Subject: RE: Request for Consultation Responses

Regarding the application for a 27.1m high wind turbine at Lower Gazegill, Cross Hill Lane, Rimington, application nr 3/2012/0954, I cannot yet complete my assessment of likely impacts on the setting of the Forest of Bowland AONB as I need to see copies of the original visualisations submitted by the applicant. One of your colleagues has very kindly offered to send me a disc with the images loaded on.

3/2012/0954/P - Lower Gazegill, Cross Lane, Rimington (27.1m to tip)

Figure 1: Zone of Theoretical Visibility Results

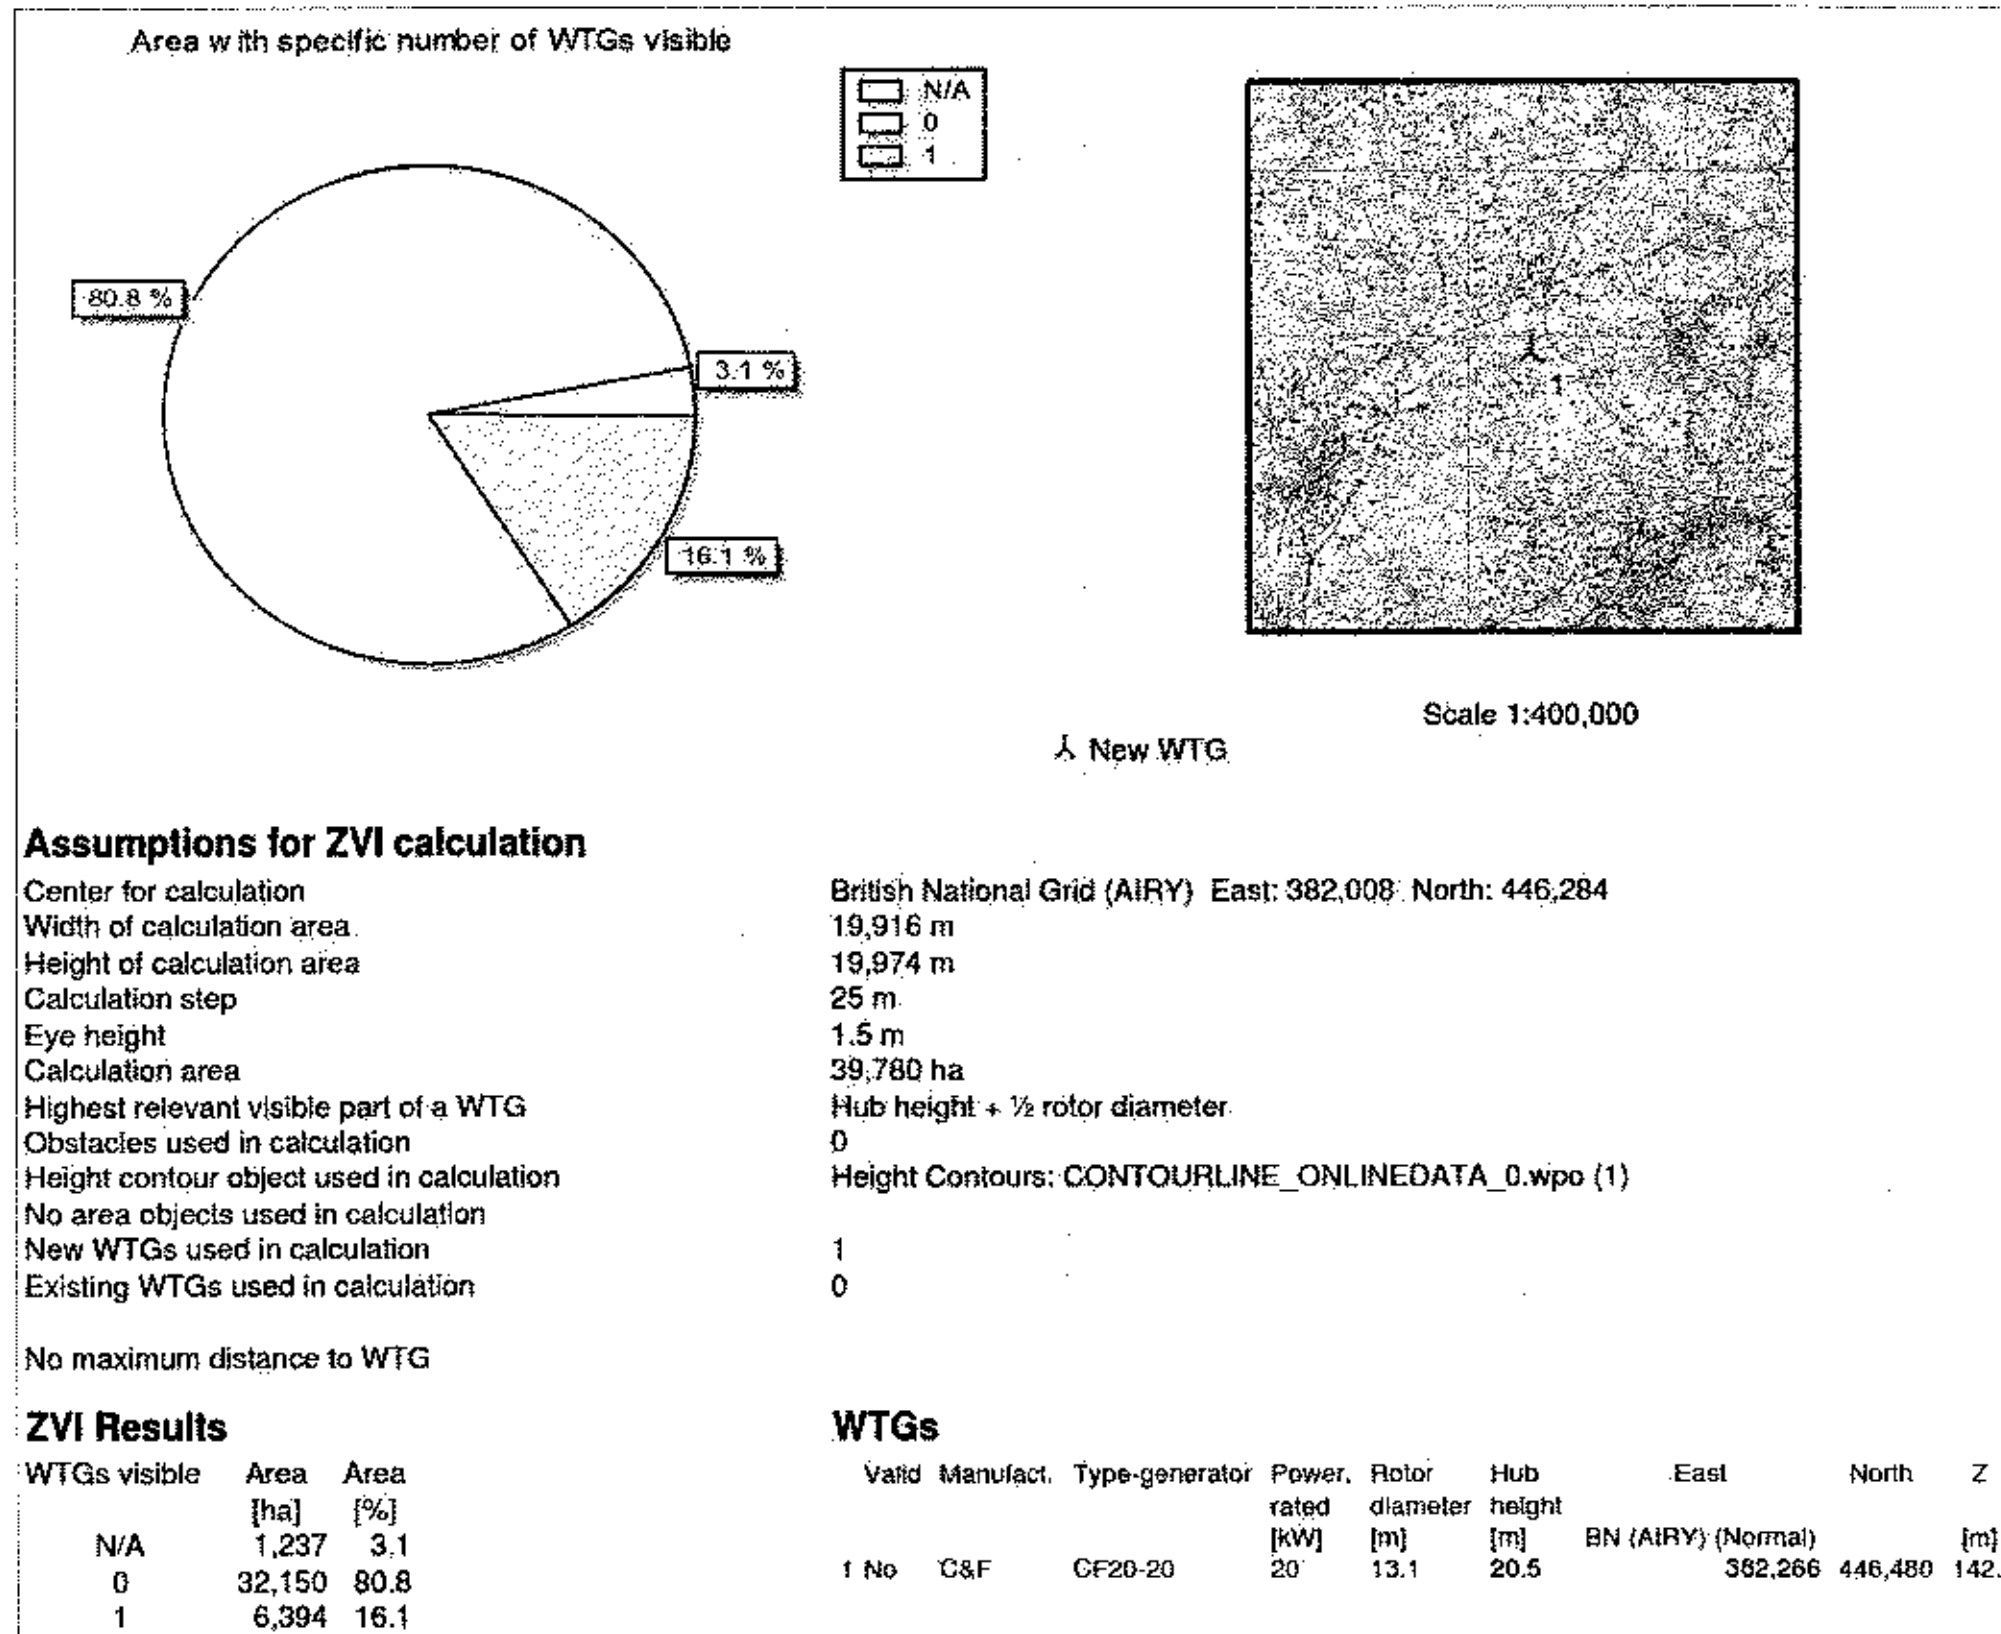
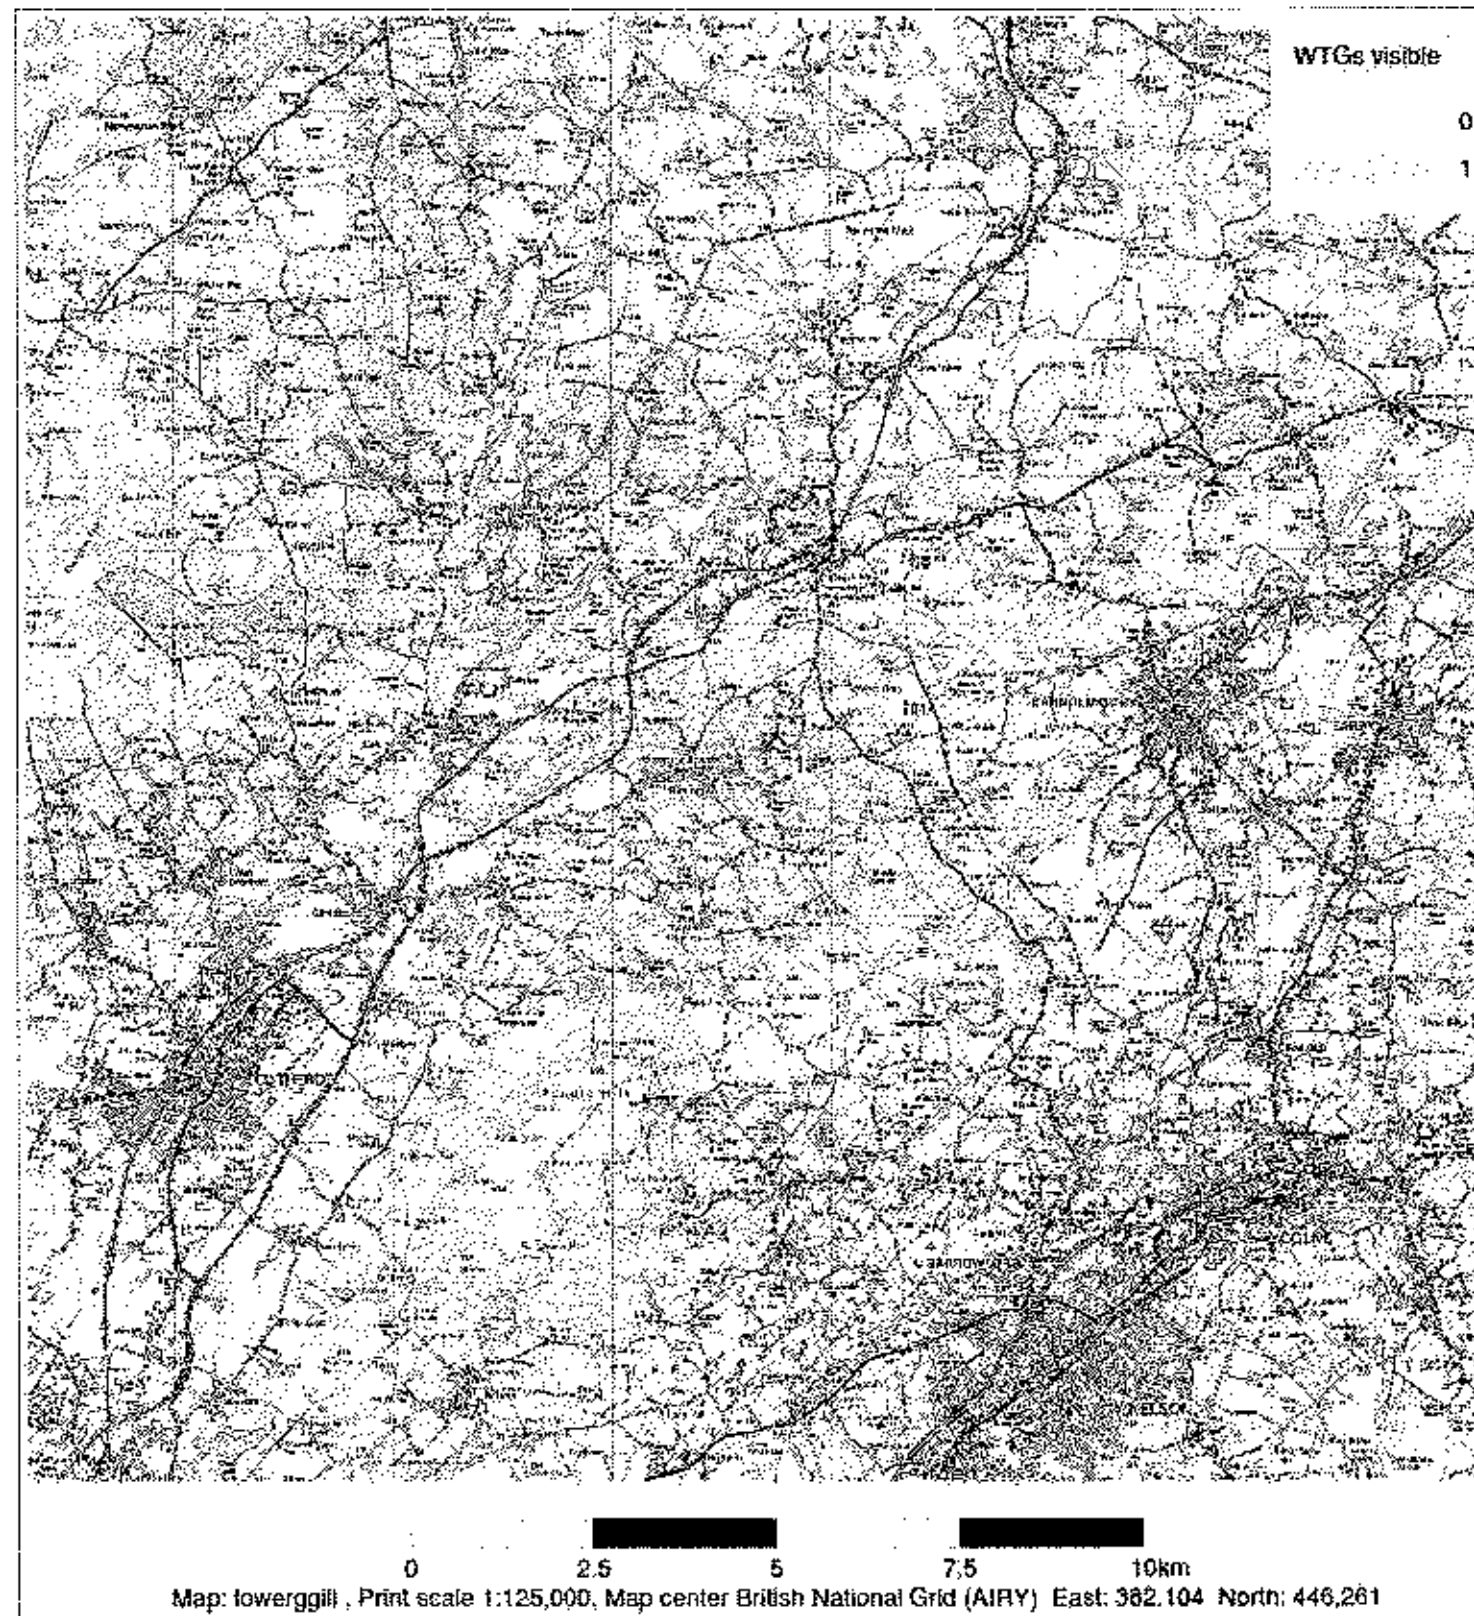
- c) No zone of theoretical visibility mapping has been provided. This is an essential tool for use in conjunction with photomontages to determine the likely significance of landscape and visual impacts.

Viewpoint 1 Existing

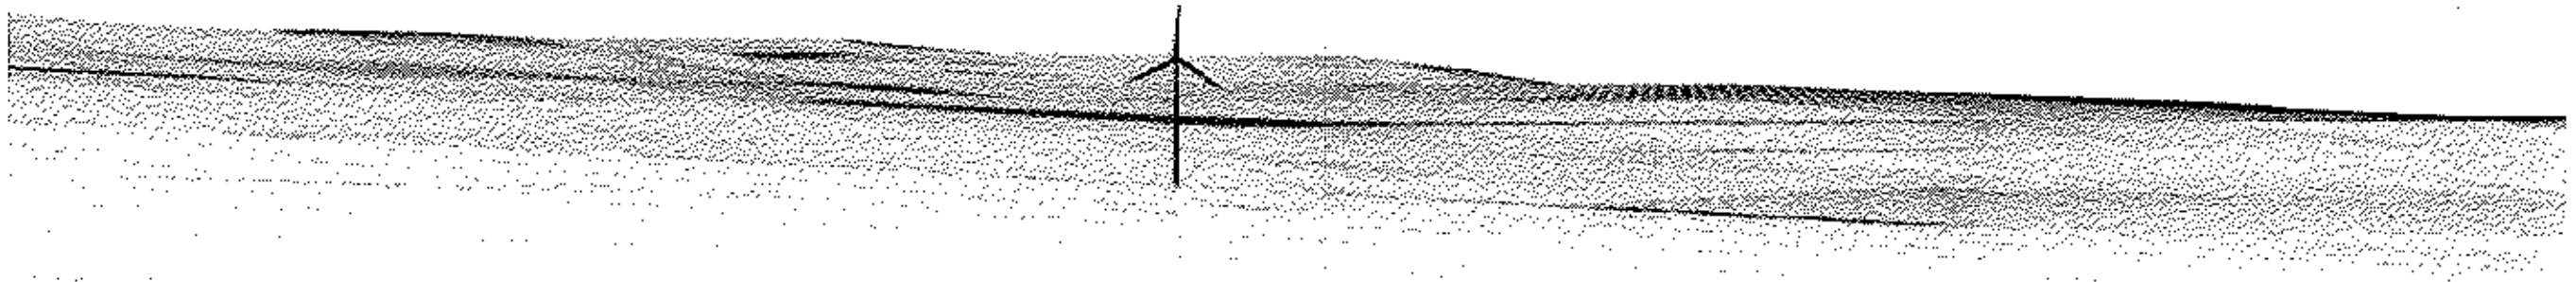
- h) A photomontage produced from a single frame image taken with a 75mm lens focal length should be produced for viewpoints 1 and 2.
 - i) the wireframe drawings have a very compressed vertical scale. This needs to be taken into account when assessing likely landscape and visual impacts.
